From: [REDACTED]
Sent: Damian Sullivan
06 February 2014 09:56
To: [REDACTED]
Subject: WSCC response A/140/13 Brackenside, Dappers Lane, Angmering
Attachments: Brackenside Sight Line.Visibility Splays. 010_C.pdf

The new vehicular access to the site shall be laid out to provide visibility splays as shown on the approved plan Proposed site and location plan (drawing number 10075-010 Rev C dated 05-02-2014) insofar as the red edge marking ownership of the land defined in the Location Plan permits.

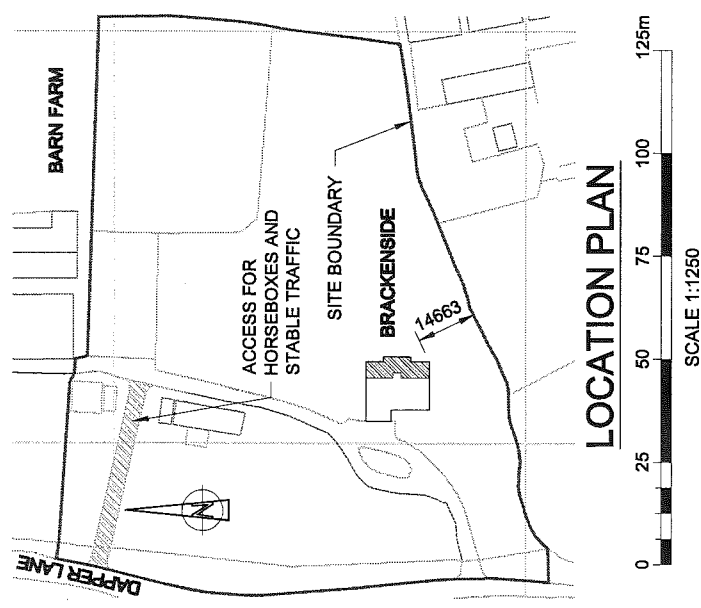
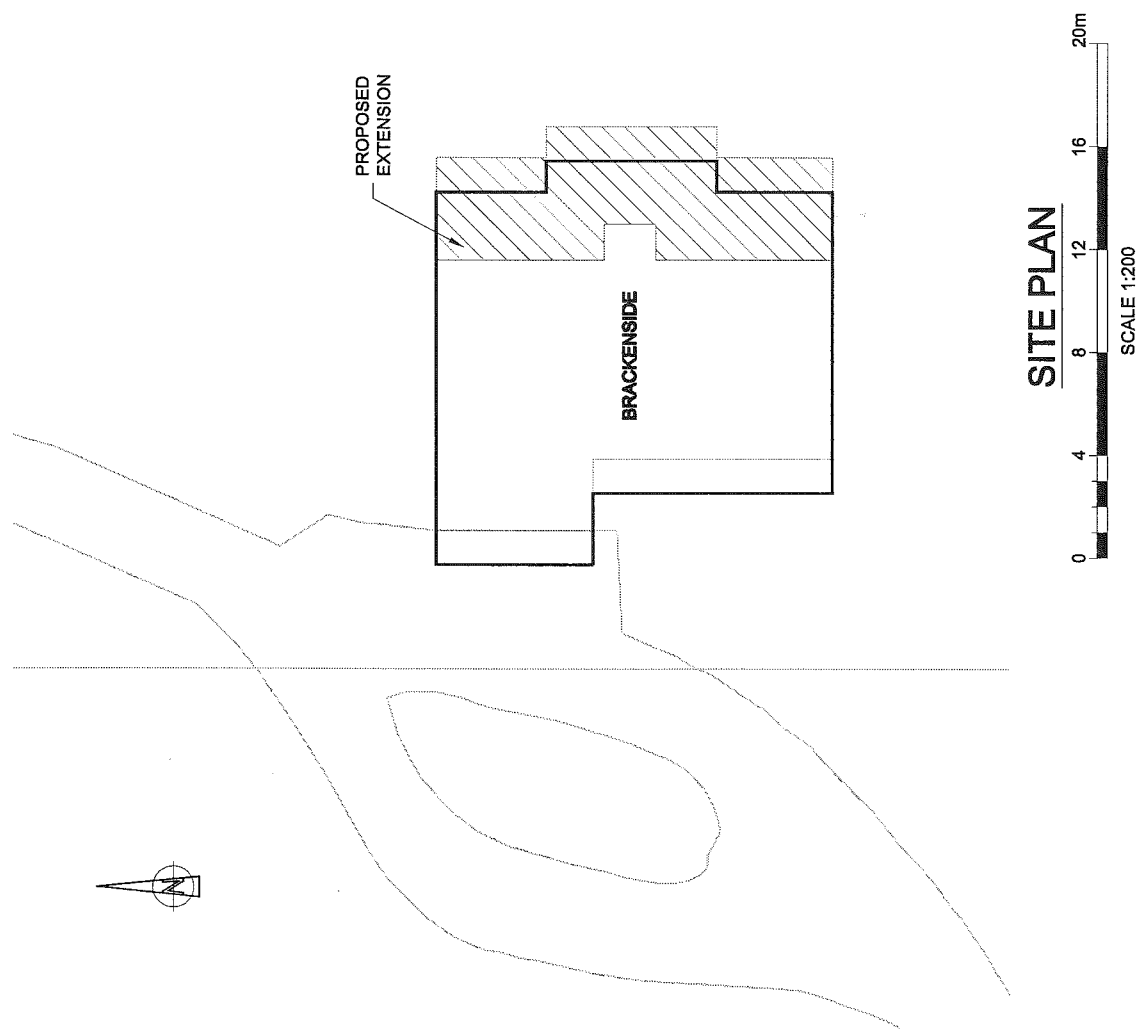
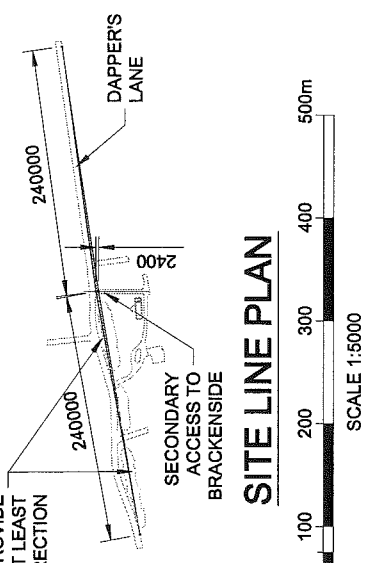
AS stated in the letter from West Sussex Highways, Dappers Lane coming from a southerly direction is 30mph up to and beyond the existing access to Brackenside and becomes a de-restricted road within 25m of the northern end of the Brackenside Site. At that point Dappers Lane becomes a single track carriageway, which serves two properties to the North of Brackenside and a woodland nature reserve. Access from the north into Dappers Lane via Arundel Road/ Village Road and Patching is not permitted to any vehicle except the local bus service.

Therefore, we now have until tomorrow at 3pm for you to send me an e-mail stating that the owner can achieve the requested 240m sight lines outside their red edge so that an associated condition requesting this will meet the test of reasonableness for Committee.

In order to address your comments/concerns with this site, especially the fact that the owner does not have control for the full distance of the sight lines are you happy with the following condition:-

I am attaching a revised site plan with sight lines shown thereon, which meet the requirement set out, by W. Sussex Highways, subject to some cutting back of overgrown hedging within the Brackenside curtilage. The verge to the east of Dappers lane over the 240 m length of sight line varies between 3m and 8m providing excellent visibility over that 240m length.

I have been able to speak with my client, the applicant, who she has advised me that, in accordance with the West Sussex Highways Authority's requirements, she can confirm that she is in a position to control the 2.4m x 240m site line to the north of the proposed new access.

No other work shall be carried out on the site until the above-mentioned sight lines and splay lines have been provided and thereafter the said sight lines and splay areas shall be kept free from any obstruction to visibility in excess of 0.6 metres above the level of the adjoining carriageway.
